Consultation Response from Alan Smith, KC Waste Strategy (Refuse & Recycling)

2026/91136 rear of, 28, Northorpe Lane, Northorpe, Mirfield, WF14 0QN

Discharge of details reserved by conditions 3 (retaining walls (materials)), 4 (retaining walls (specification)), 12 (waste arrangements (permanent)), 13 (waste arrangement (temporary), 29 (charging electric vehicles) on previous permission 2021/91914 for demolition of one dwelling and erection of 44 dwellings with access and associated infrastructure

Responding Ref: WPN 26 022

project.	Northorpe Lane, Mirfield		
drawing title.	Proposed Site Plan_Bin Presentation Points		
date.	scale.	paper size.	
23.03.26	1:250	A0	
drawing status.	drawn by.	checked by.	
Planning	TM	MC	
project no.	dwg no.	rev.	
2026-157	107

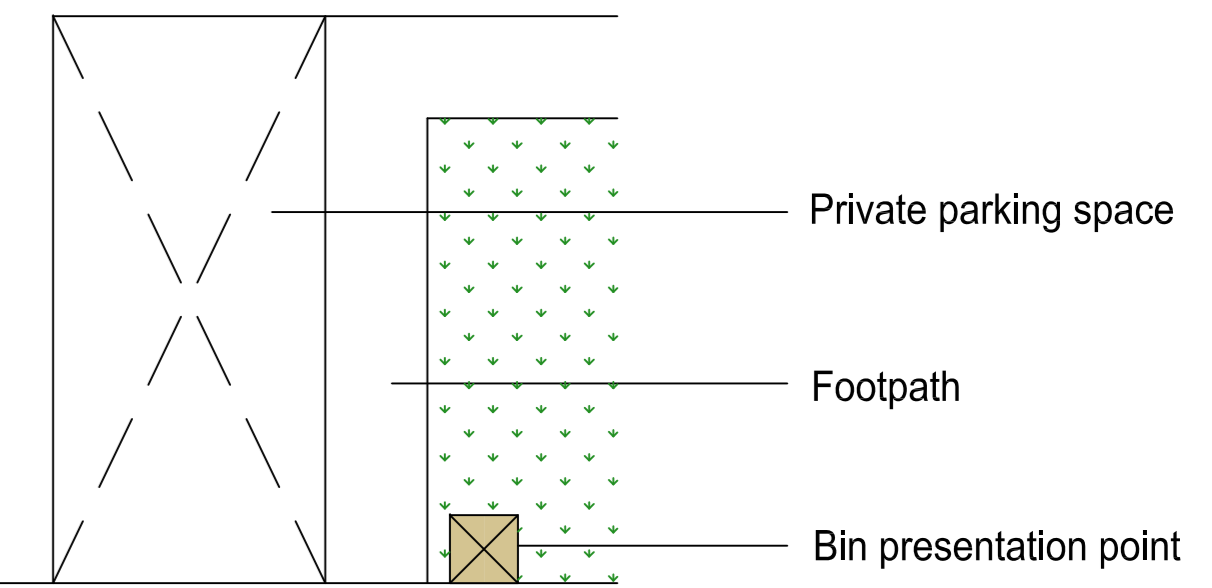
For Condition 12 the developer has submitted a drawing Proposed Site Plan Bin Presentation Points, Project No. 2026-157, Dwg No. 107.

Given the information provided by the developer the WCA can agree to the Discharge of Condition 12 for the site.

There is insufficient information to agree to the discharge of Condition 13. The WCA will not enter any site which is not complete and construction is still taking place. Details of temporary collection points will be needed where there is sufficient safe turning space. Until this is provided the temporary collection location will be at the junction with Northorpe Lane.
